April 1, 2021

Subject: Bjorkman Administrative Conditional Use Permit (ACU-20-00003)

JASON BJORKMAN PROPERTY

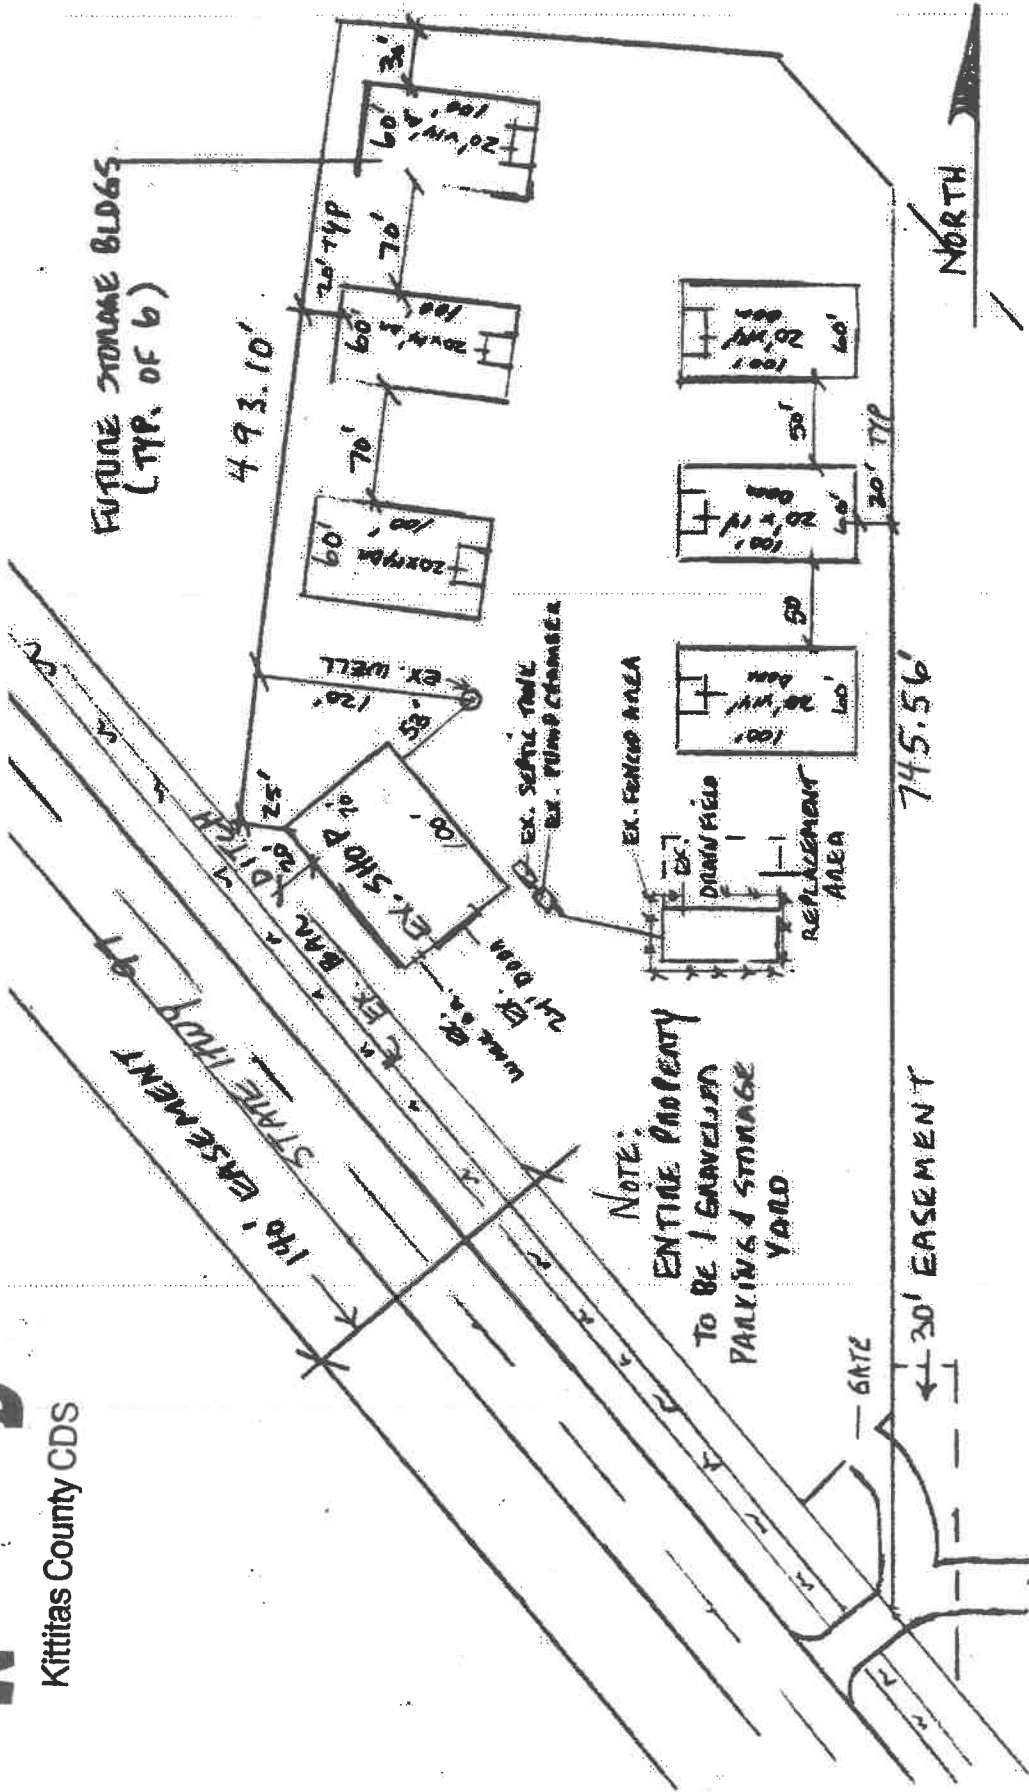
- 1) Revised site plan depicting:
 - a. The orientation of the storage buildings, specifically the face of each storage structure.
 - b. Additional detail in regards to the setbacks from property lines, points of access, roads and parking areas.
 - c. Location of the existing well, septic tank, drainfield and the drainfield replacement area.
